Notice of Modification

Section 75W of the *Environmental Planning and Assessment Act 1979*

The Project Approval for the East Guyong Quarry Project, granted by the Land and Environment Court of New South Wales on 21 May 2012 (06_0193).

Figure 3: Neighbouring residences

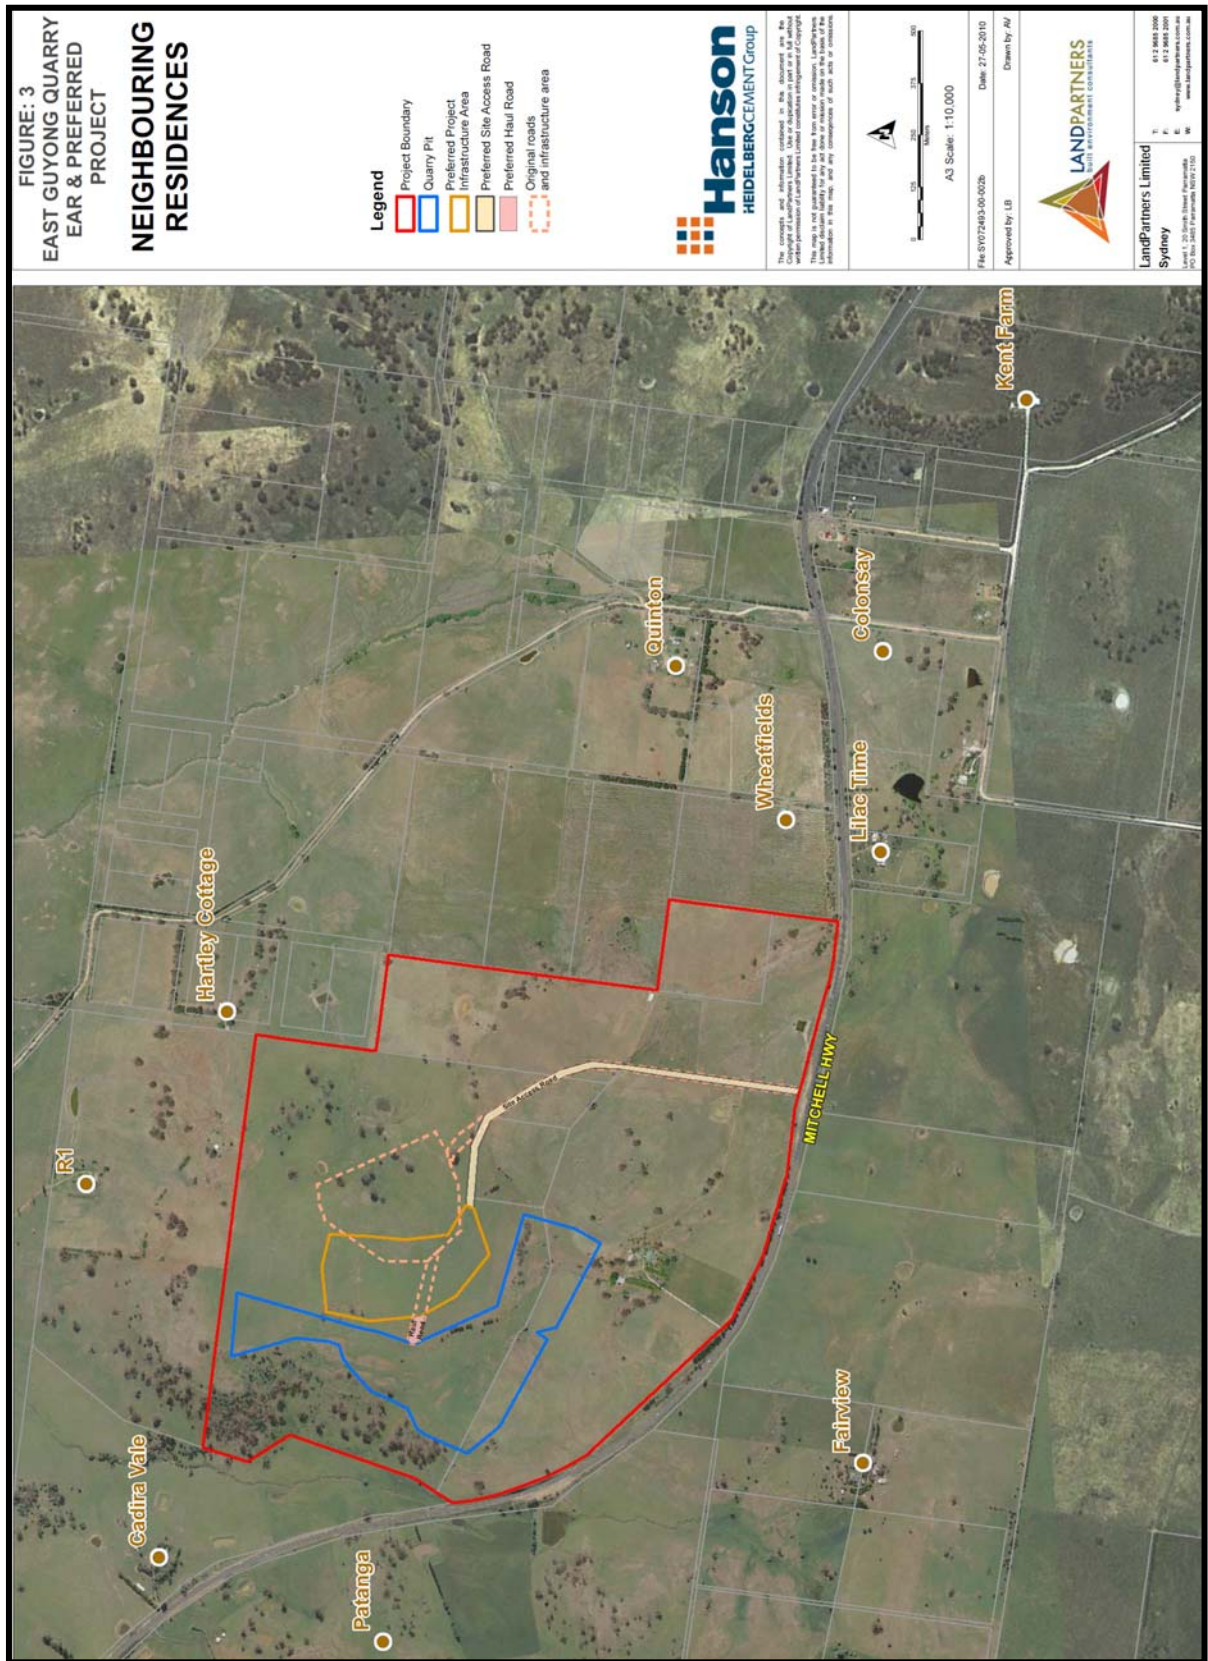
EA (MOD 1) – Environmental Assessment titled *East Guyong Quarry - Section 75W Planning Assessment Report*, dated November 2012
2. In condition 2 of Schedule 2, delete all words after "commitments;" (except the notes), and replace with the following:
 - c) EA (MOD 1); and
 - d) conditions of this approval.
3. In Appendix 1, delete the Figures and replace with the following:

Figure 3: Neighbouring residences
